From: Steve Roseland <stever@lmc.nsw.gov.au>
Sent: Friday, 17 October 2014 5:30 PM
To: Ben Eveleigh
Subject: RE: Council's submission on Modification to existing consent for Dry Boat Storage and Marine Facility, ROZELLE BAY (MP06_0210 MOD 7)

RE: Modification to existing consent for Dry Boat Storage and Marine Facility, ROZELLE BAY (MP06_0210 MOD 7)

Total RBPL Water Area = 11,410 metres square

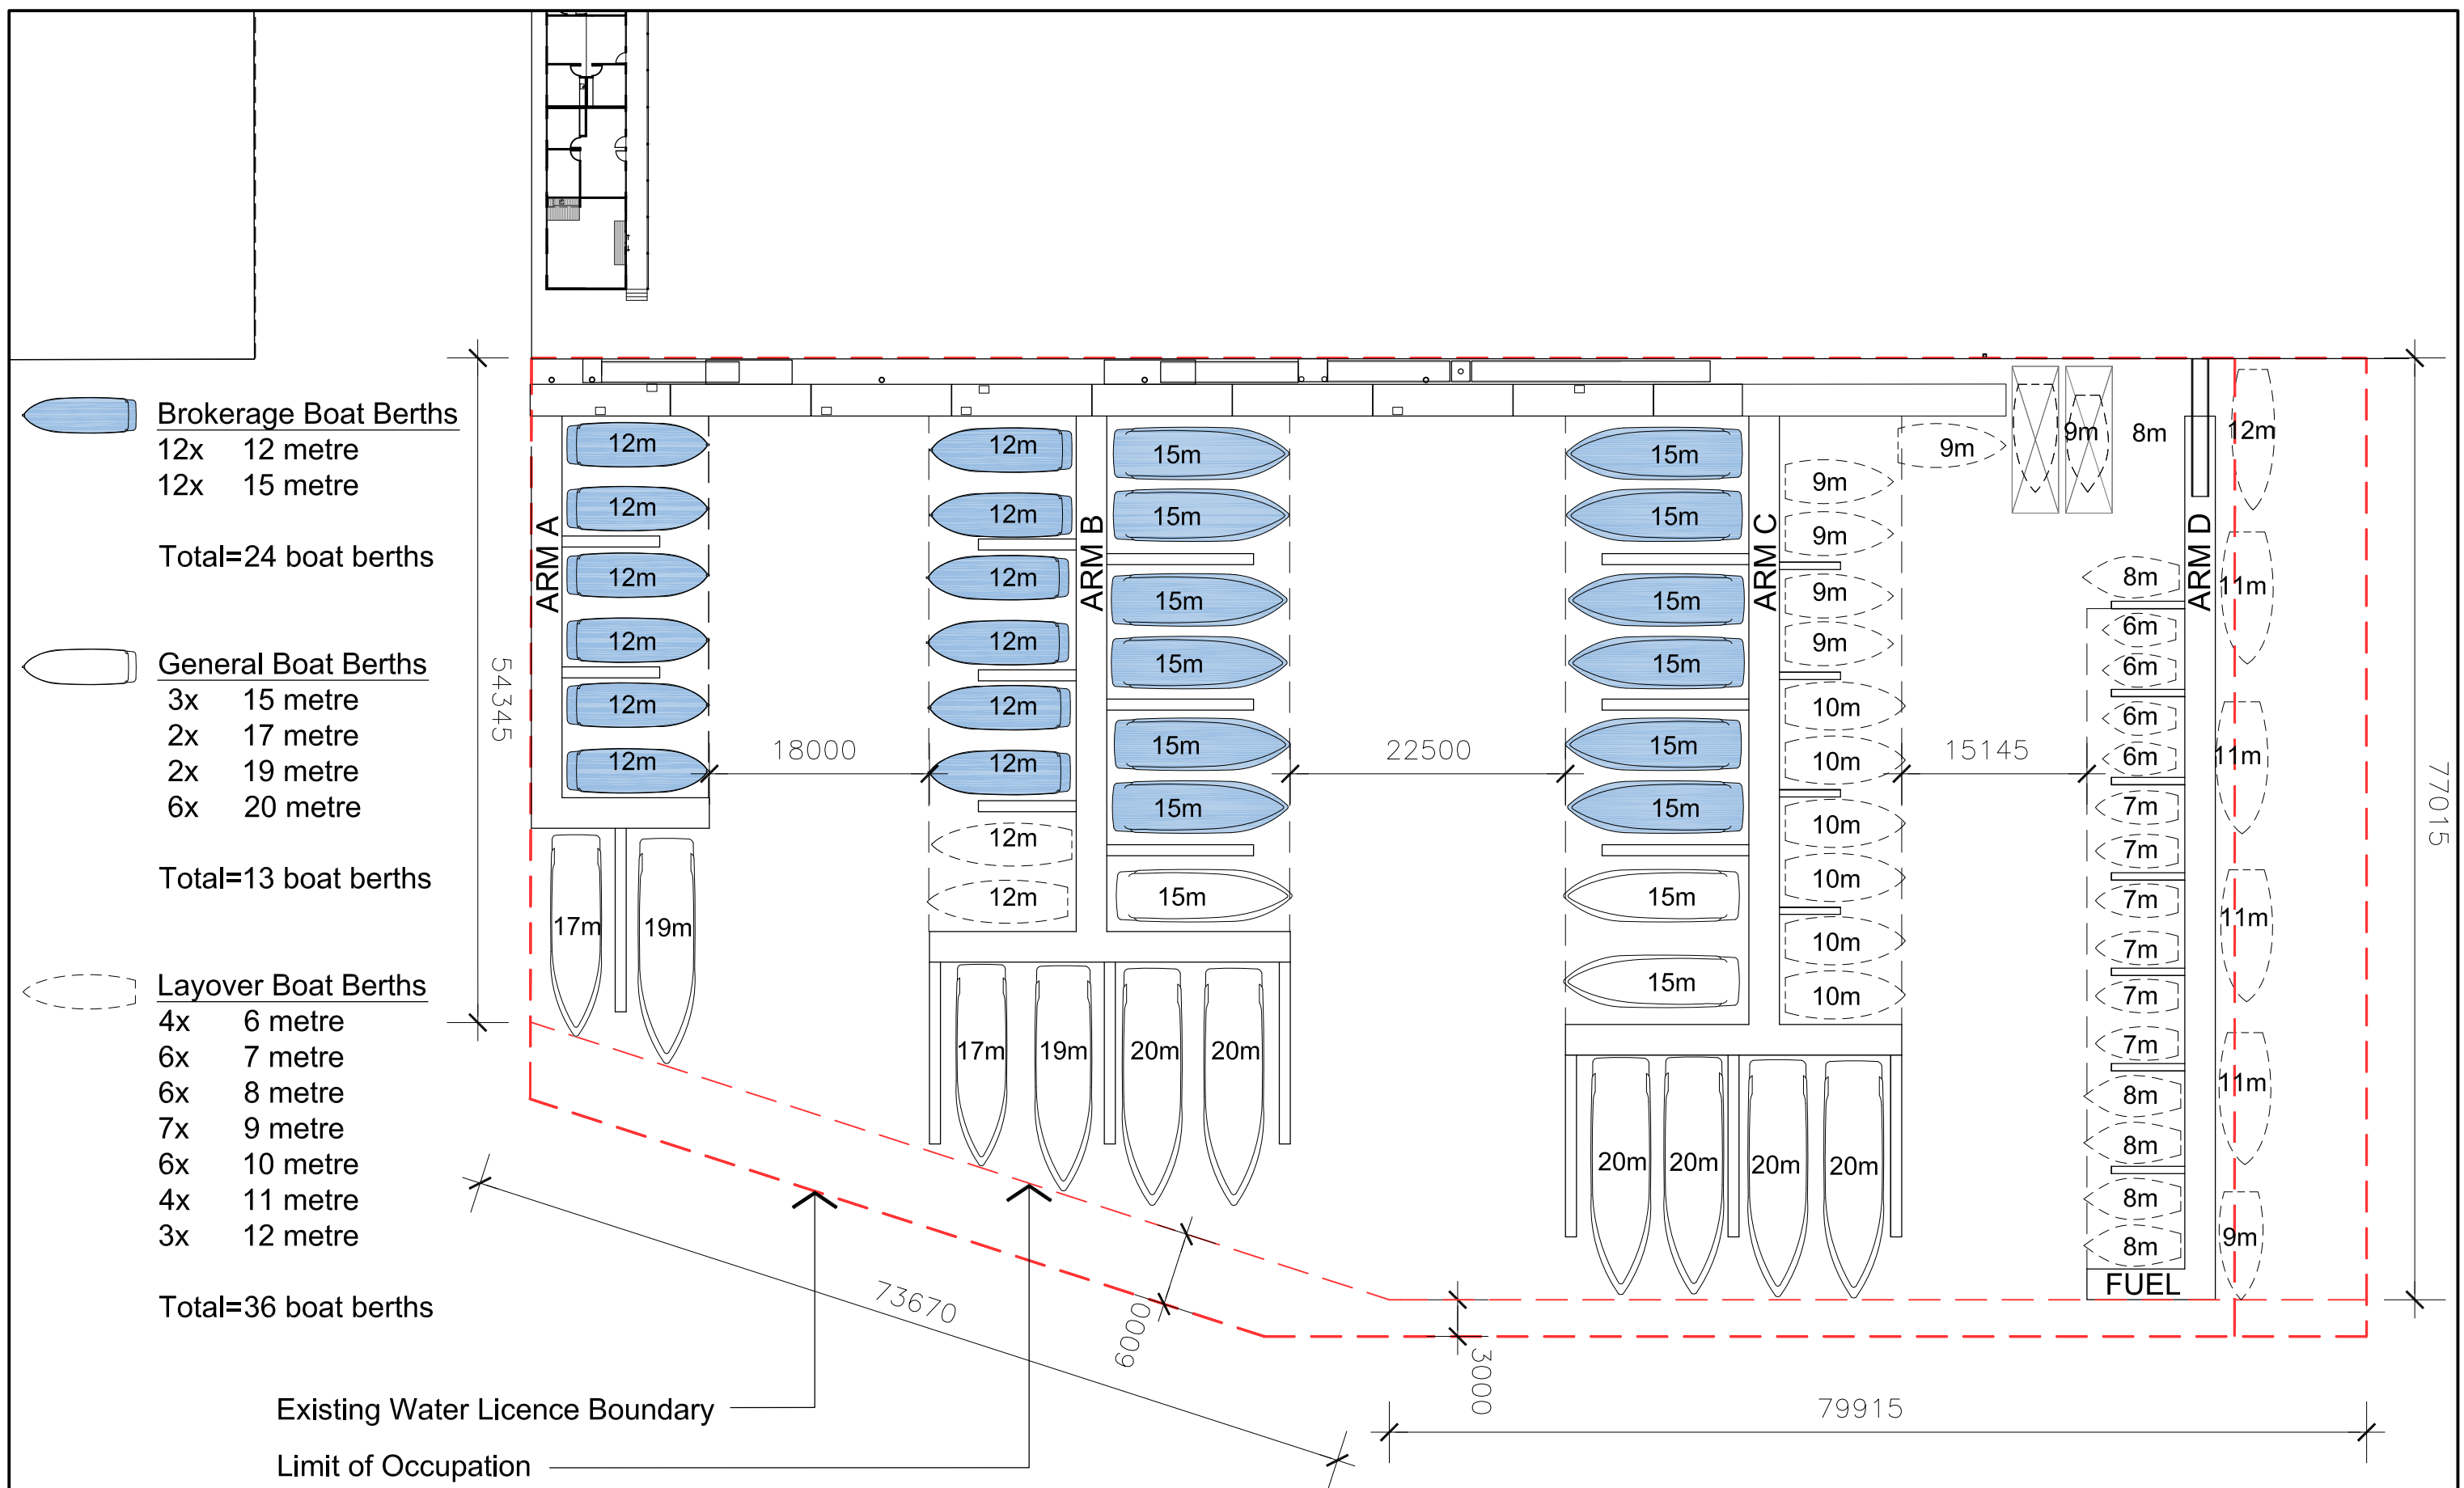
Reconfiguration of the marina

Condition B1(c) of the existing consent aims to ensure that brokerage boats stored in the water as part of the facility are to be used primarily for display purposes and not for general use, to be moved only by employees of the facility and only within a defined period during the day.

One of the outcomes of the proposed reconfiguration of the facilities berths would be to allow the brokerage berths to become immediately accessible from the wharfs with immediate access to the Bay resulting in operations more like those seen at a commercial marina used for launching recreational craft. It is possible that this change will see an increased number of boat movements and this must be assessed as part of the Vessel Traffic Management Plan to ensure that the condition is enforced and the facility operates as intended by the consent.

The original report on the proposed development and following consent aimed to alleviate the concerns of passive recreational users who had made submissions on the proposal by stating that the facility would not be constructed to the full extent of the water licence area. This would mean boat movements into and out of the facility could take place within that area to reduce potential impacts upon those users and the public waterway.

The current modification aims to construct wharves and berths to the limits of the water licence area. The potential impact of this change on the public waterway must be assessed prior to approval being granted. This assessment should take other concerns raised by Council such as the ambiguous number of boats that could use the facility and the number of boat movements into and out of a reconfigured facility into consideration.
